## DECISION DELEGATED TO HEAD OF PLANNING

**Application No:** H16-1111-22      **Applicant:** Mrs F T Mir Javadi  
**Proposal:** Change of use from residential dwelling to HMO  
**Location:** 106 Halmer Gate Spalding  
**Terminal Date:** 11th January 2023

J175-PL1A

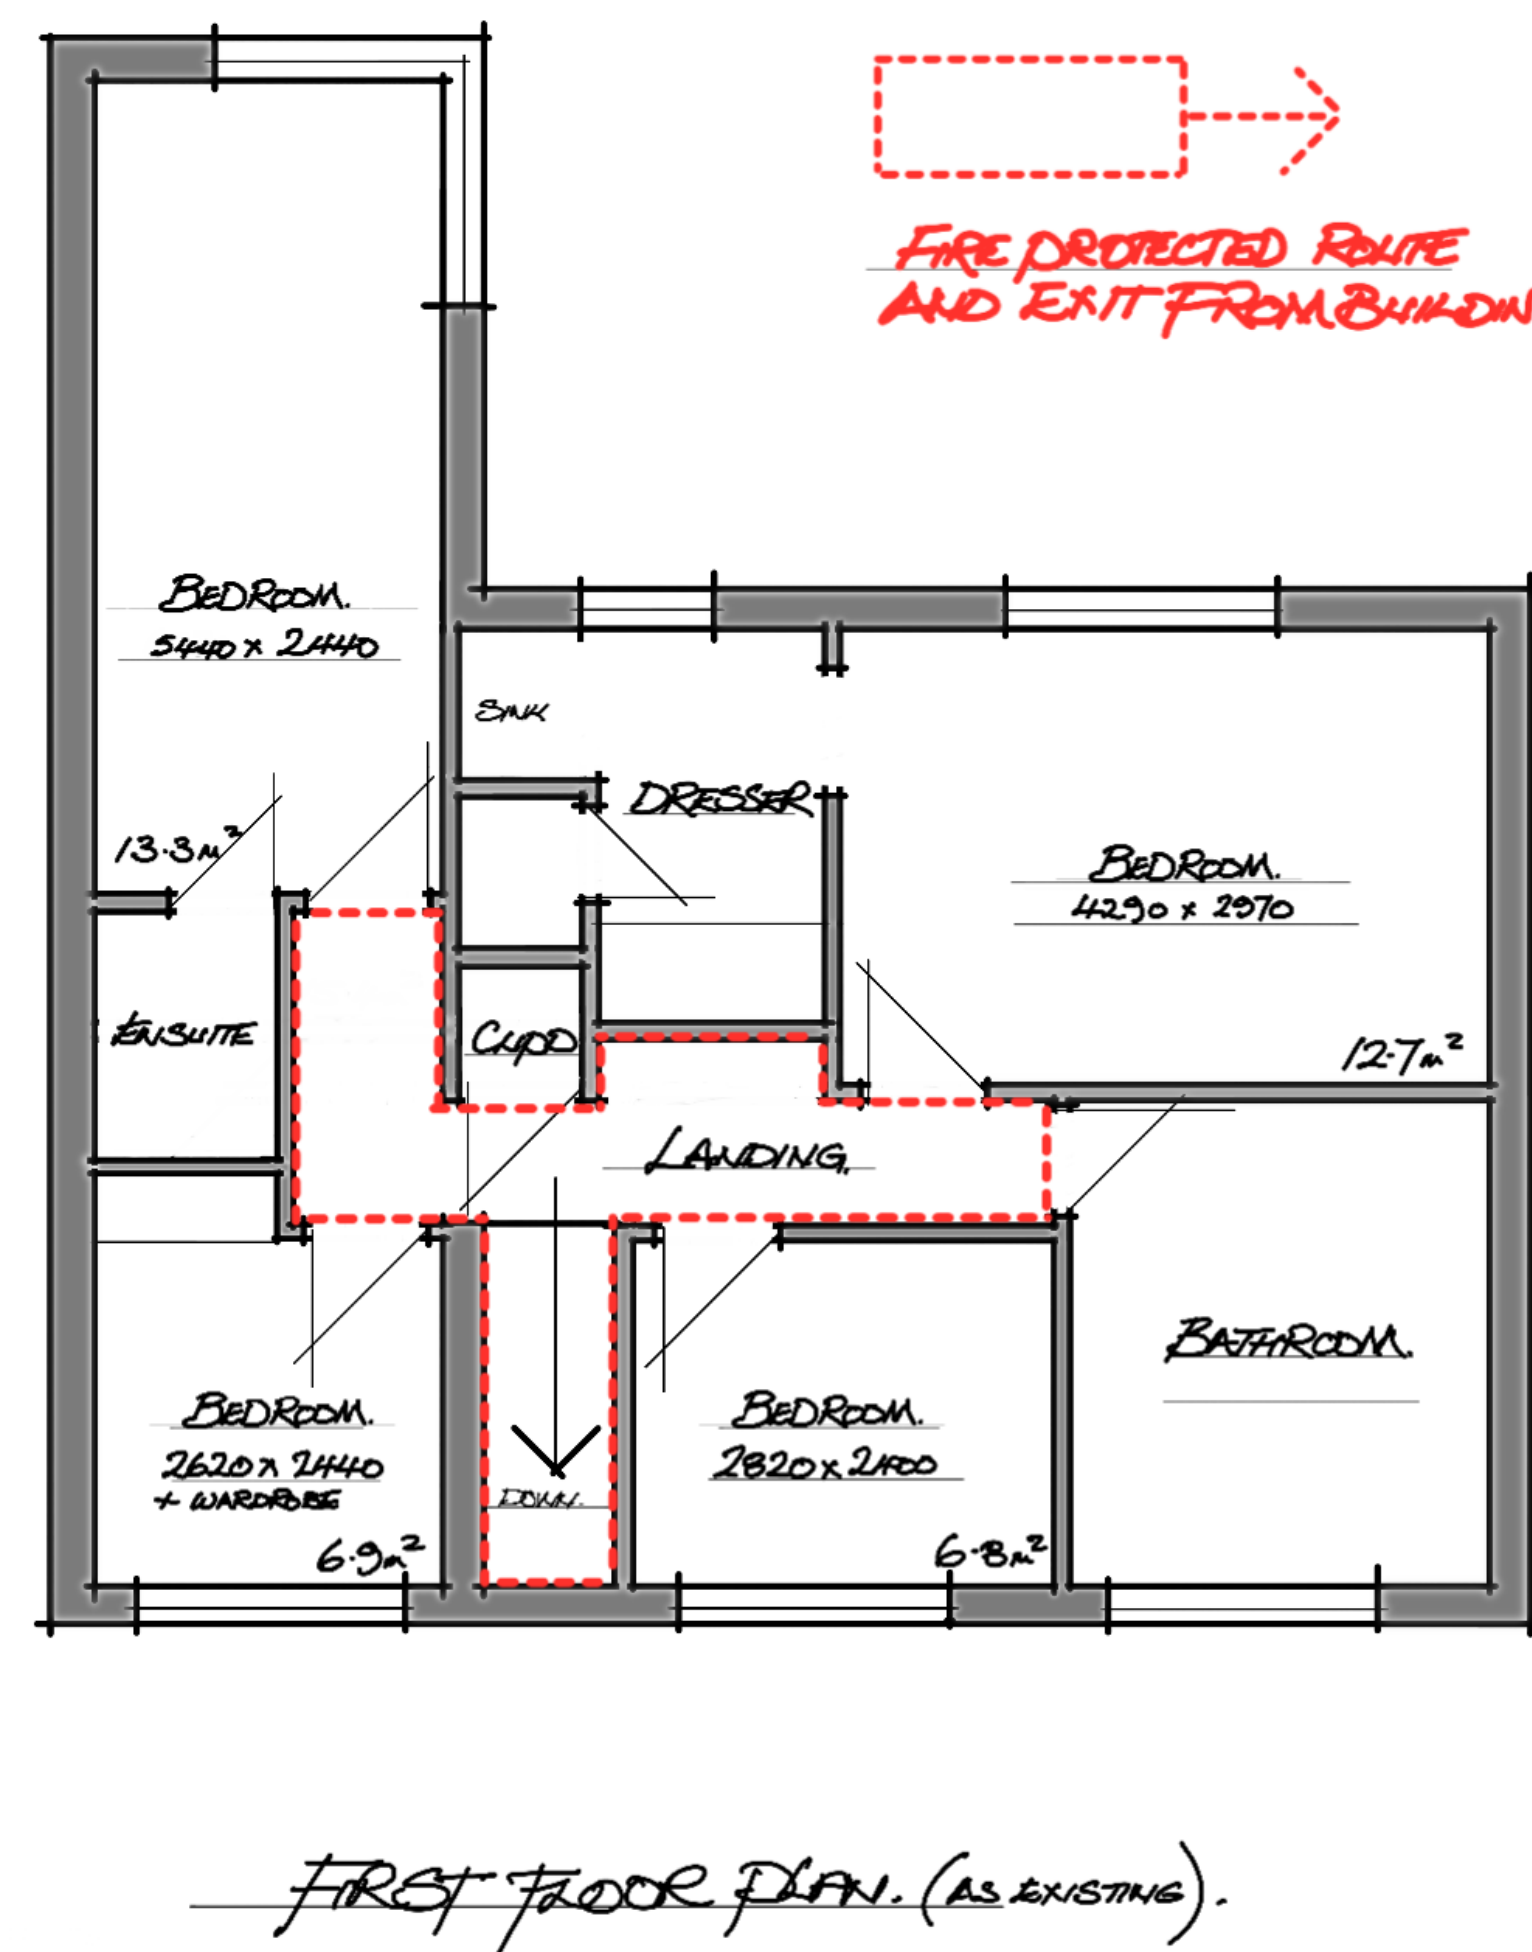
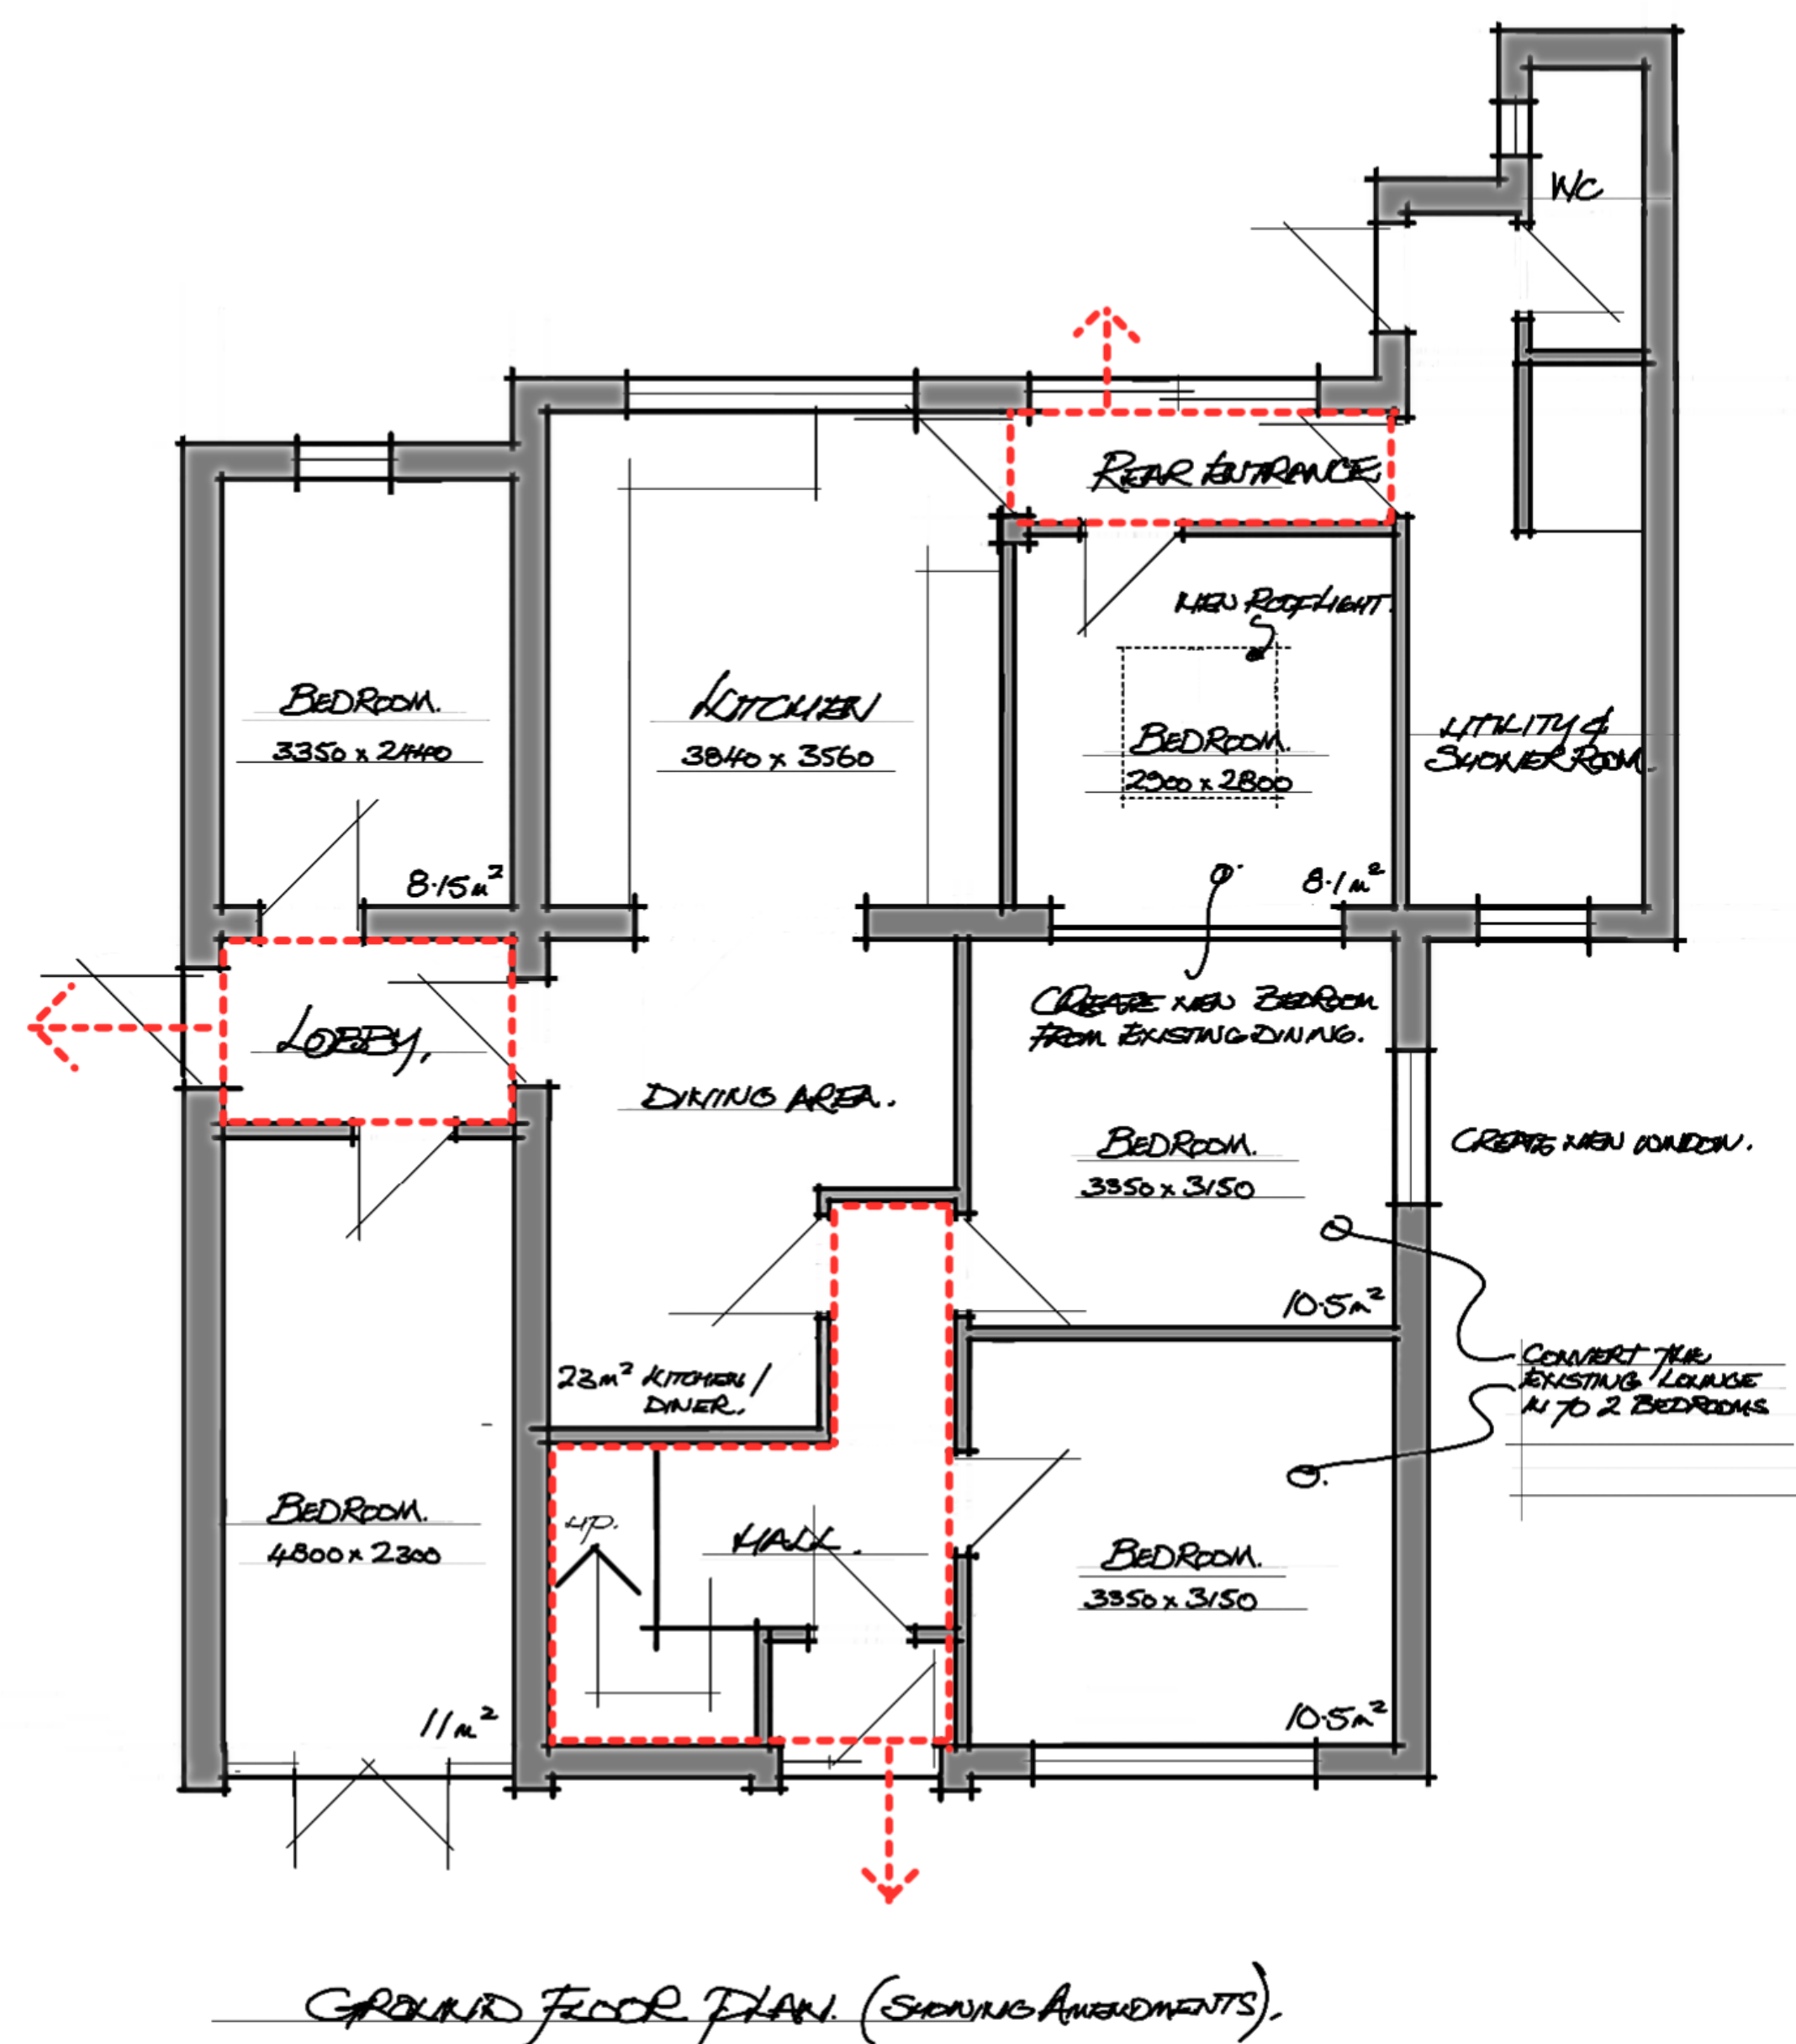
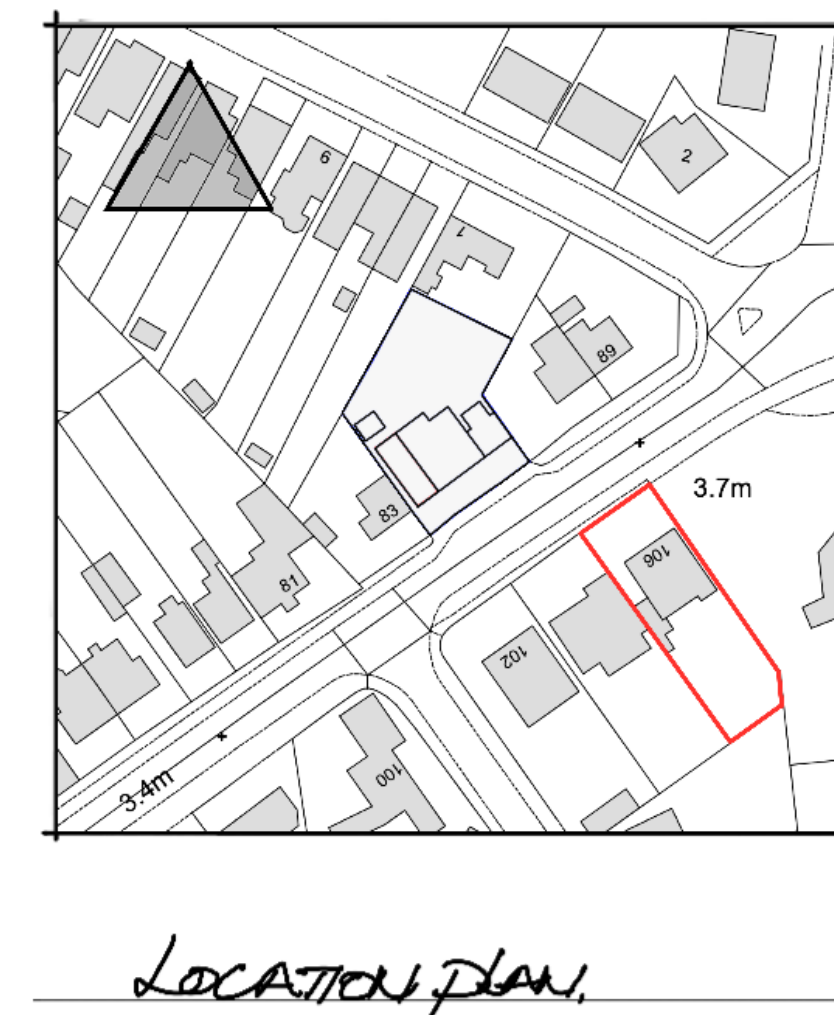
1. The property, whilst the size of a family dwelling, is not in a high density street of terraced / semi-detached properties.
2. The supporting Design and Access Statement indicates that the property would be adapted to accommodate 9 bedrooms. This is an increase of 3 bedrooms on existing (6 existing bedrooms specified on application form). It is considered that increasing the number of occupants in the property will lead to a rise in noise and general disturbance by virtue of an increase in the number of persons residing in the property and associated vehicle movements, coupled with limited internal amenity space. Consequently, the proposal is not considered to satisfactorily accord with this criterion.

7. The bedroom sizes are not considered acceptable. All of the ground floor bedrooms can only be for a single bedspace and, to the first floor, there are two bedrooms which do not comply with the Nationally Described Space Standard (2015), with only one room to the first floor which is sufficient

as a double room. There is no communal living room and only one kitchen and dining room for 9 bedrooms. This will not be conducive to well-being and will likely lead to outdoor gathering, which could have a consequent amenity impact on neighbouring properties. Therefore, the proposal is not considered to accord with this criterion.

The alterations comprise of converting the existing living room into two separate bedrooms, the existing dining room will be converted into another bedroom, creating a new rear entrance. A new window will be formed to the south east elevation on the ground floor, for one of the proposed bedrooms.
